TfNSW Reference: SYD14/01375/05
Council Reference: SSD 6799 MOD 2

MODIFICATION FOR COLD STORAGE FACILITY - LOT 10201 HOLLINSWORTH ROAD, MARSDEN PARK

Figure 5 | Proposed site plan (stage 1)

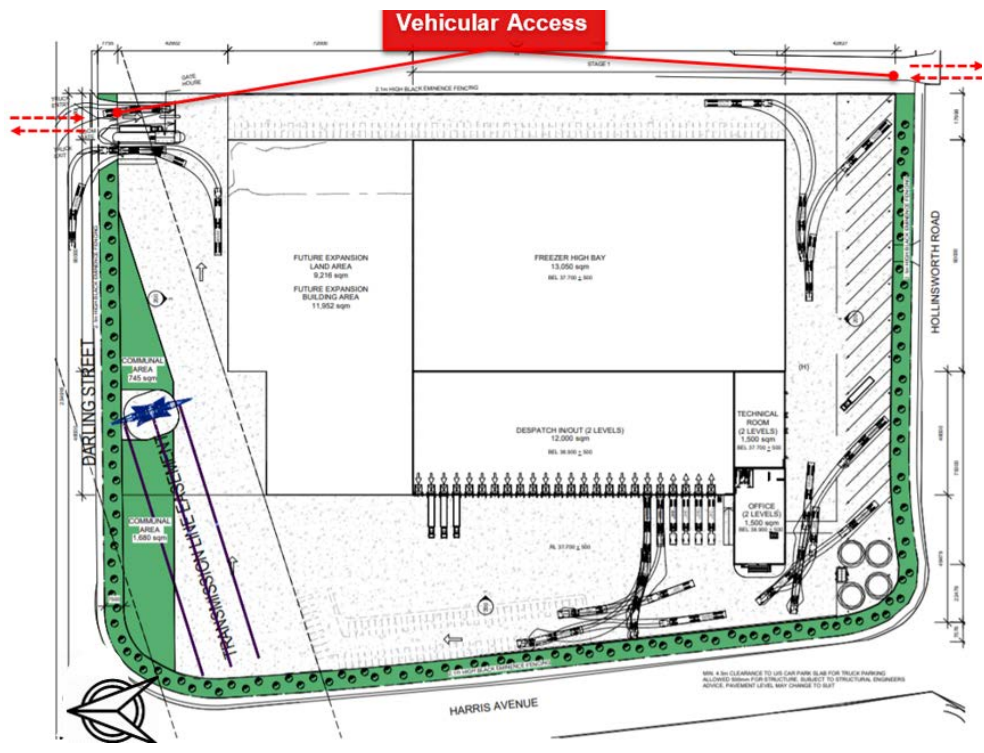
1. *Traffic Impact Assessment* - Section 3.2 Vehicle Access – It is proposed to amend the approved vehicle access arrangements and reduce the number of driveways from three to two, relocating the car park access/egress driveway on Darling Road onto Hollinsworth Road. TfNSW **does not support** the relocation of the vehicular access to Hollinsworth Road. Please note that the intersection of Hollinsworth Road and Harris Avenue is to be signalised. Any vehicular access on Hollinsworth Road and Harris Avenue frontage will have negative impact on the future operation of the signalised intersection.

2. Urbis Modification Report – Section 4.6 states “The number of loading docks is proposed to be reduced from 32 to 23.” Traffic Impact Assessment - Section 4.2 states “It is proposed to provide 34 loading docks to service the proposed development. It is requested the applicant provide clarification to the Department as to the total number of proposed loading docks and demonstrate these vehicles have been included in the requested intersection modelling.
